Transport Infrastructure Planning Unit

14 December 2023

**A12 Chelmsford to A120 Widening Scheme (the Project)  
DCO Application  
Further responses to interested parties responding to Secretary of State's Second  
Request for Information dated 20 November 2023**

Drawing title
**TRAFFIC REGULATION MEASURES
SPEED LIMITS
SHEET 14 OF 21**

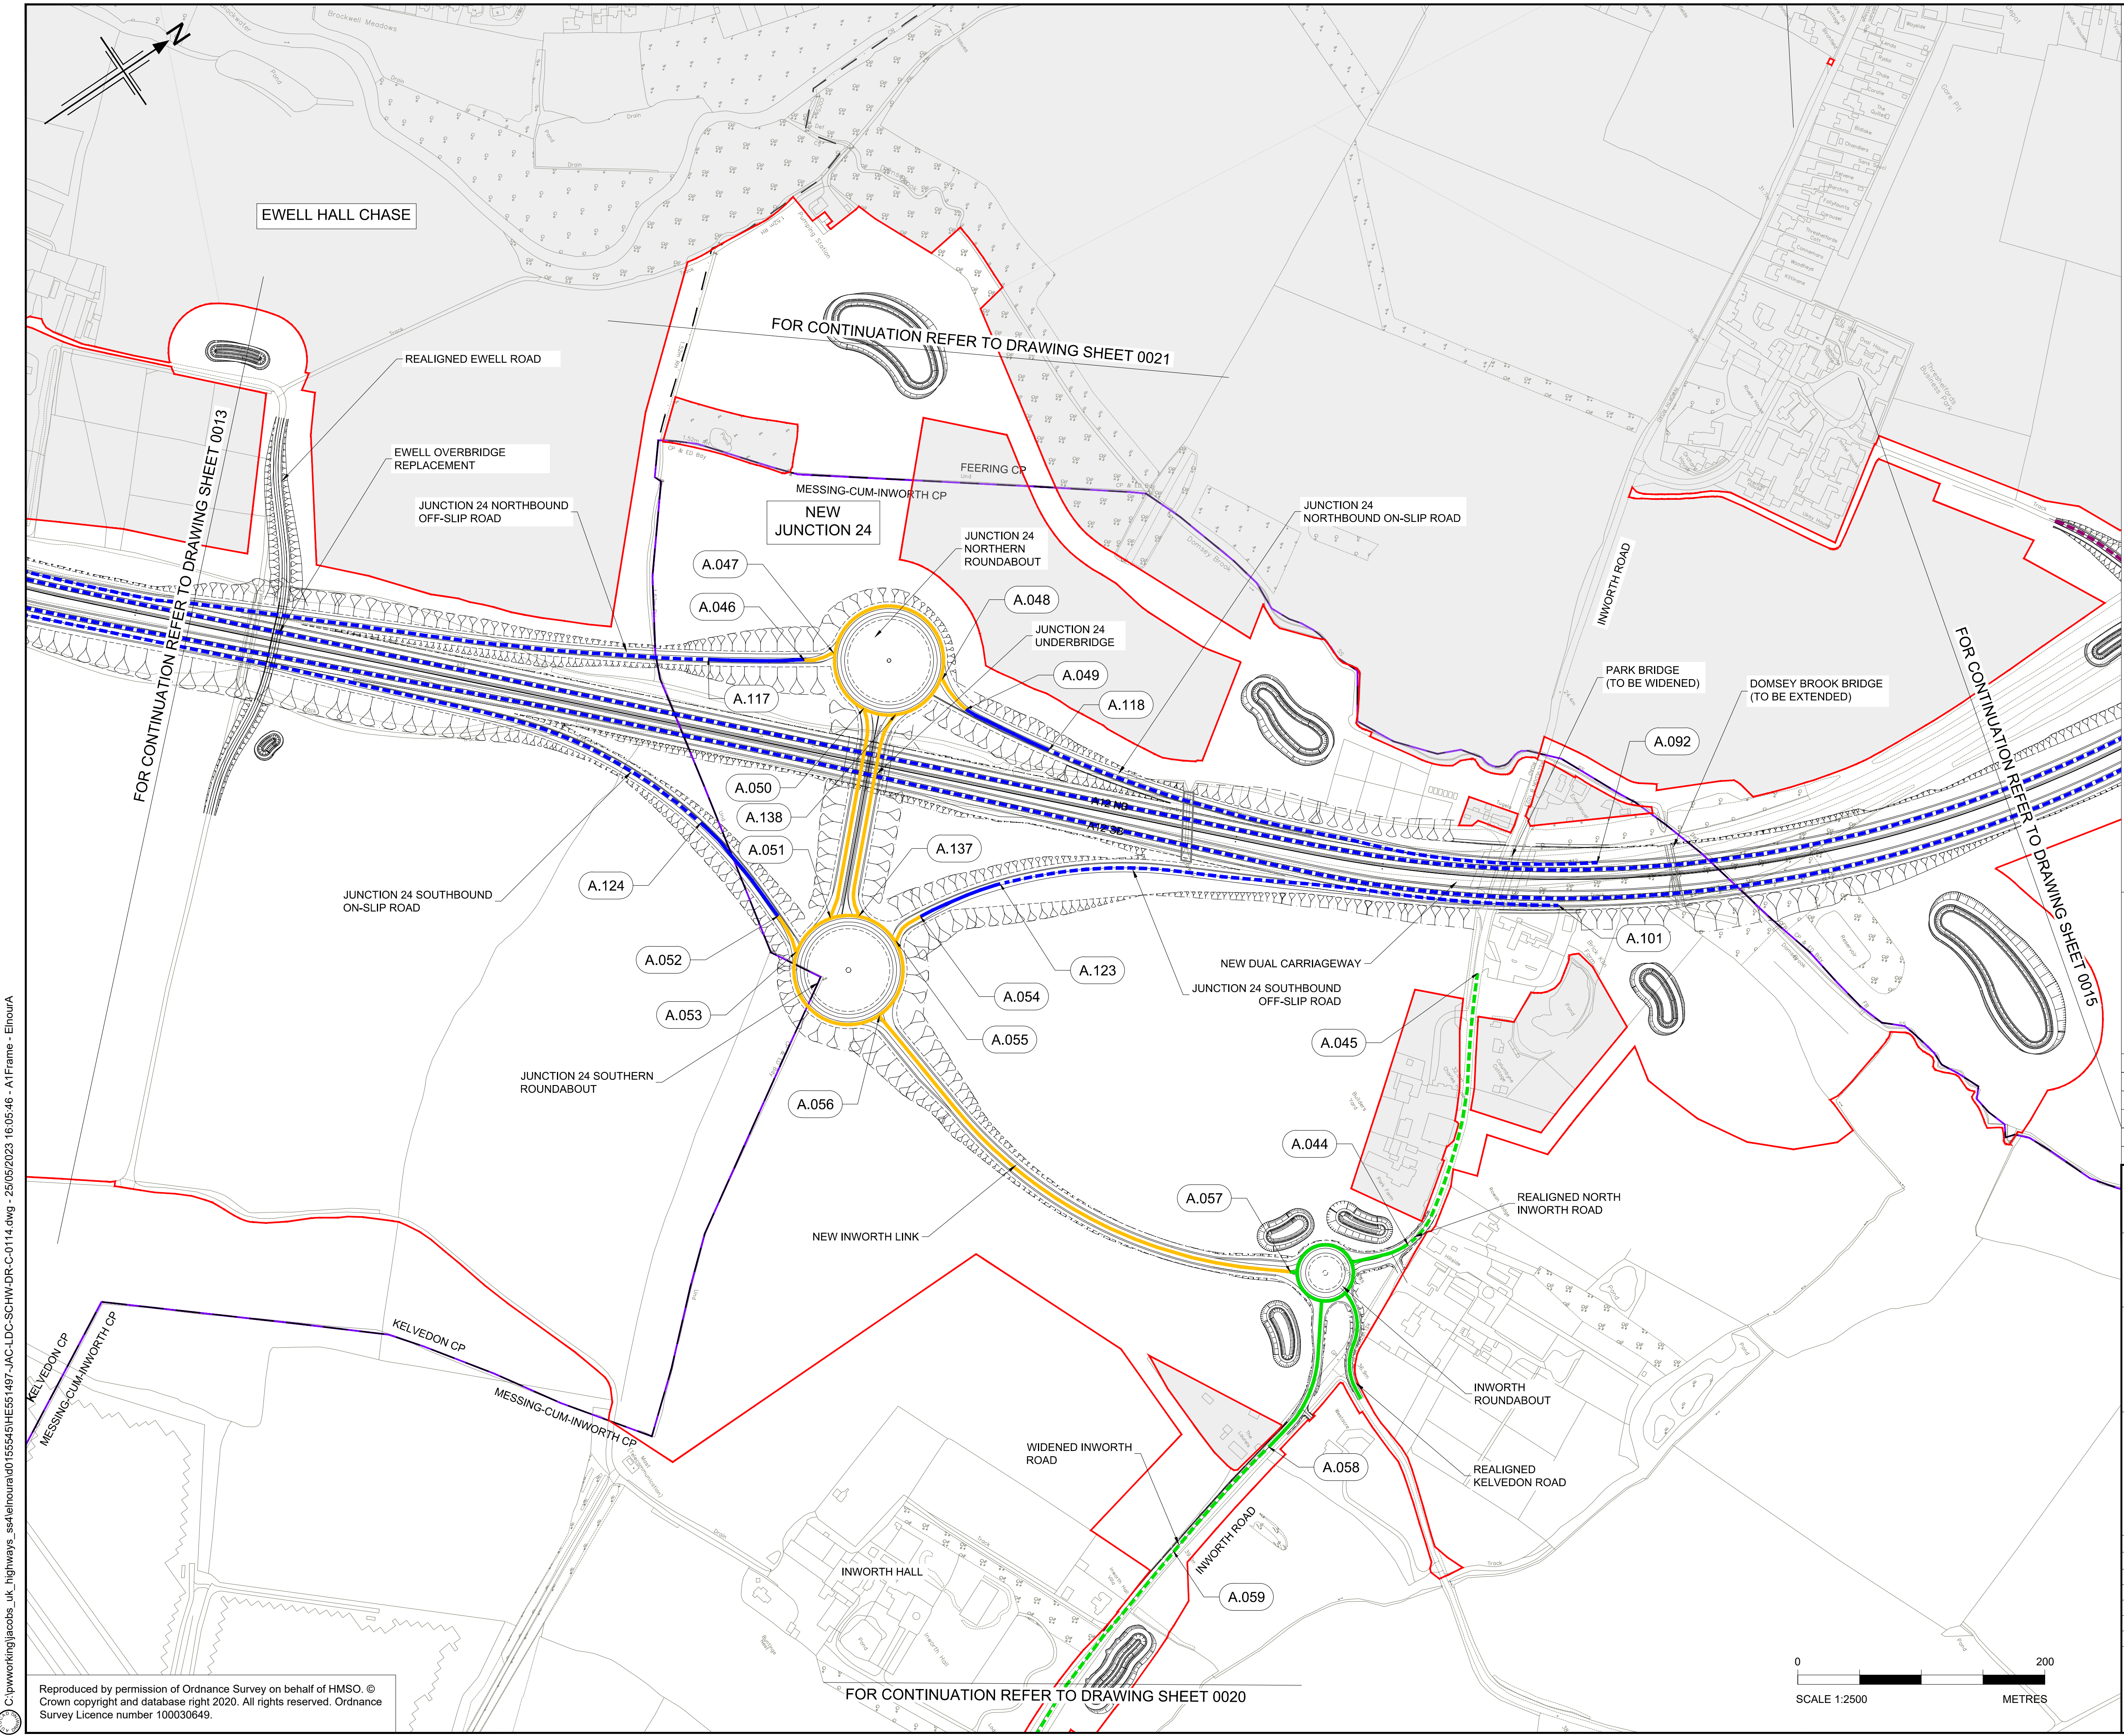
With regard to the lengths of road highlighted by ECC, the Applicant confirms its commitment to include measures, as detailed below, in the detailed design of the scheme to encourage compliance with speed limits. Initial concepts have been proposed at the joint Technical Working Group meetings with ECC and National Highways described in the Applicant's response to the Secretary of State's first consultation letter of 27th October 2023. We continue to work towards a jointly acceptable design solution and the Applicant continues to investigate and propose further amendments to encourage compliance with the posted speed limits.

- National Highways will provide, on the four roads referred to below, such suite of measures to encourage speed limit compliance, whilst according with the preliminary scheme design geometry, as may be requested by Essex County Council as Local Highway Authority (including where requested speed cameras):
  - Braxted Road (south of the junction Henry Dixon Road, Rivenhall End)
  - The new B1024 Link Road between Rivenhall End and Kelvedon
  - The new Essex County Fire and Rescue Service Access Road
  - London Road Roundabout (Marks Tey)
- National Highways will liaise with Essex County Council as the Local Highway Authority before agreeing or discounting any Road Safety Audit recommendations that may affect the local highway network.

Drawing title: ENGINEERING SECTIONS (PLAN AND PROFILES) JUNCTION 24 SHEET 1 OF 5

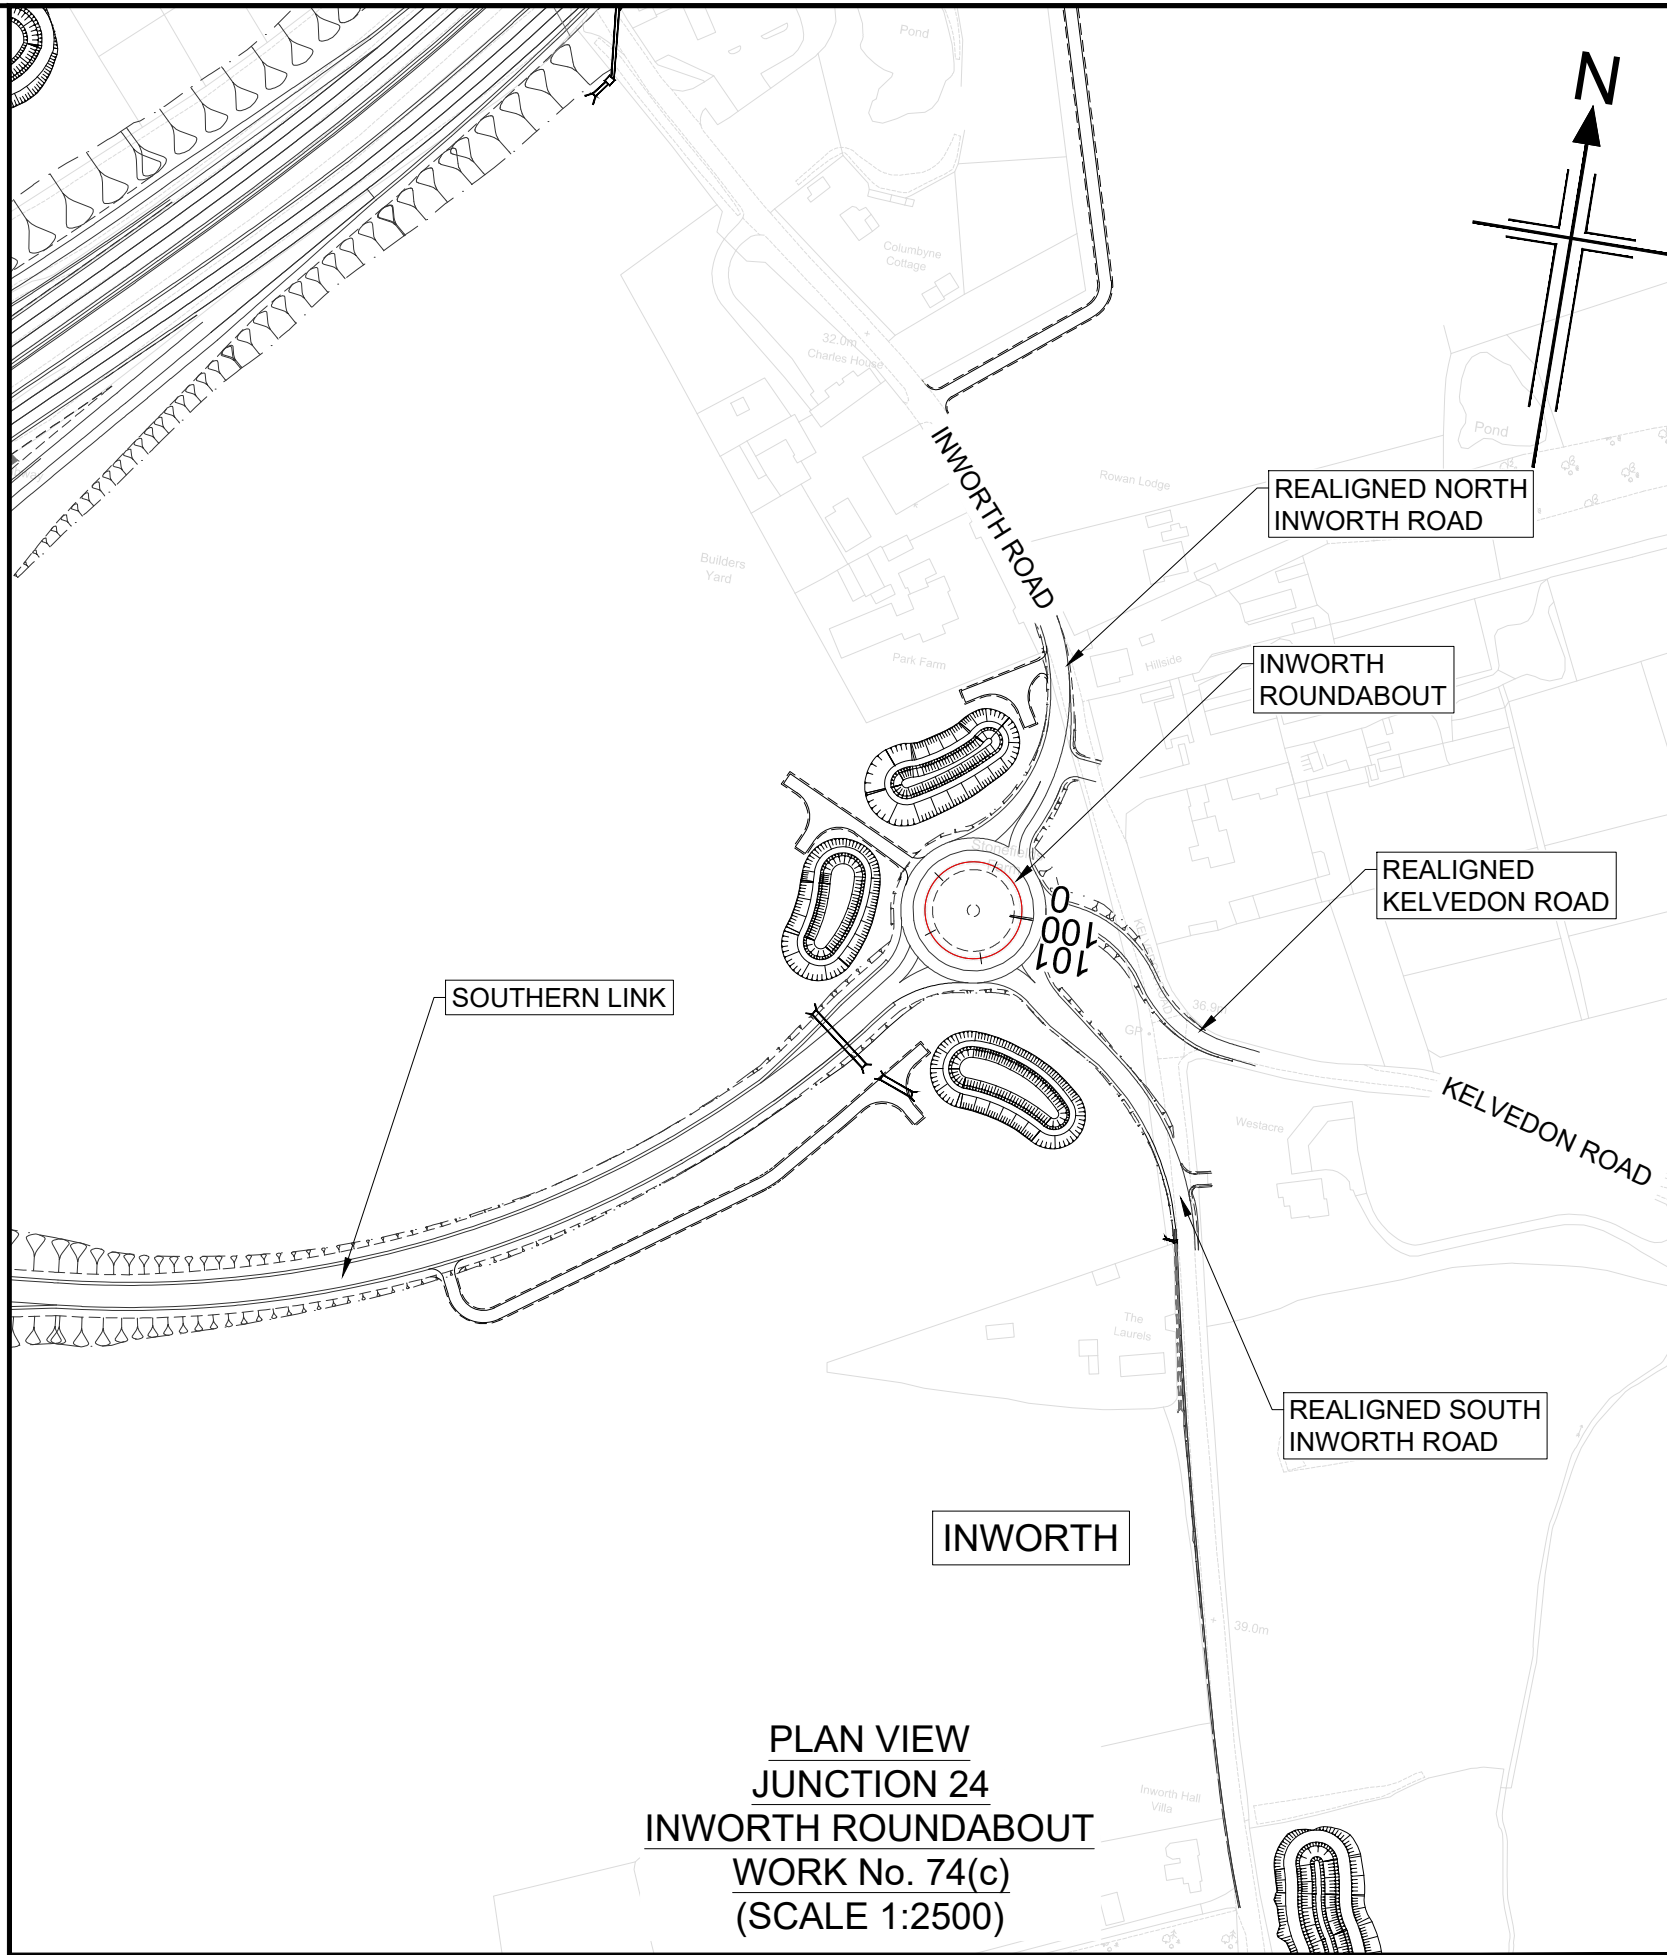
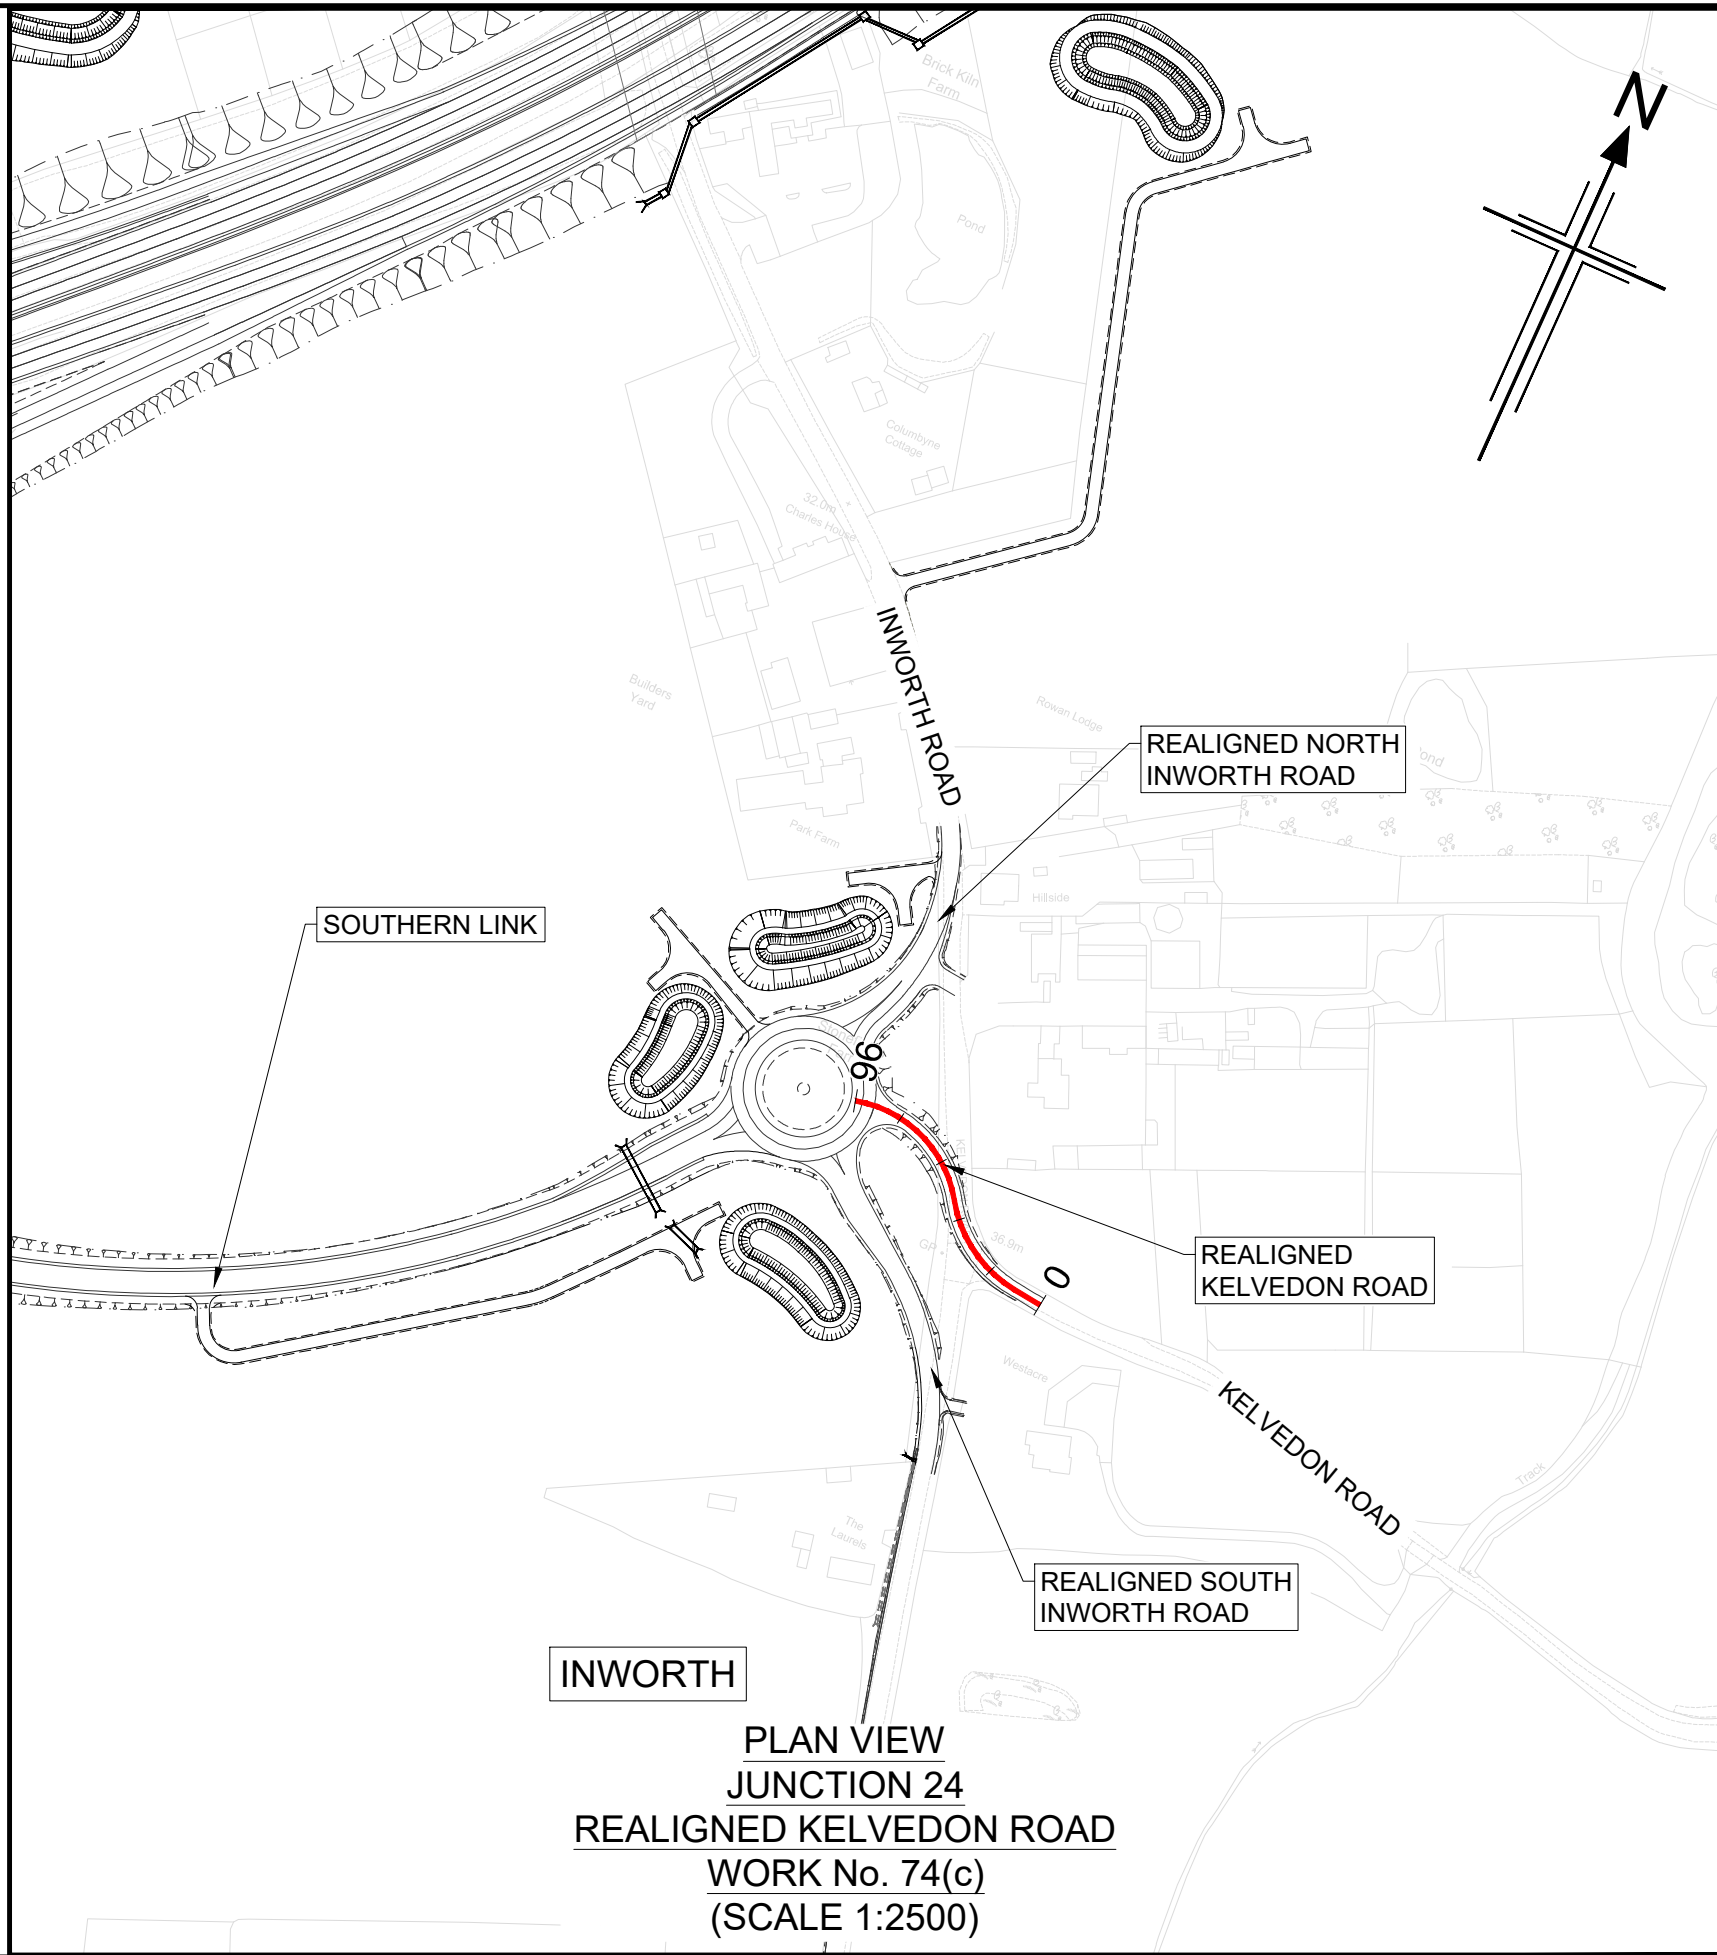
3. a) Braxted Road

The Applicant confirms that vertical alignment details were included on the Highways Engineering Sections Drawings submitted as part of the DCO Application package, showing the constrained location and vertical geometry of Braxted Road Bridge and its approaches. This has been confirmed to the Council in the Applicant's letter of 24

November. ECC has asked for further details and the Applicant continues to liaise with the Council to provide this in a timely fashion as the detailed design becomes available.
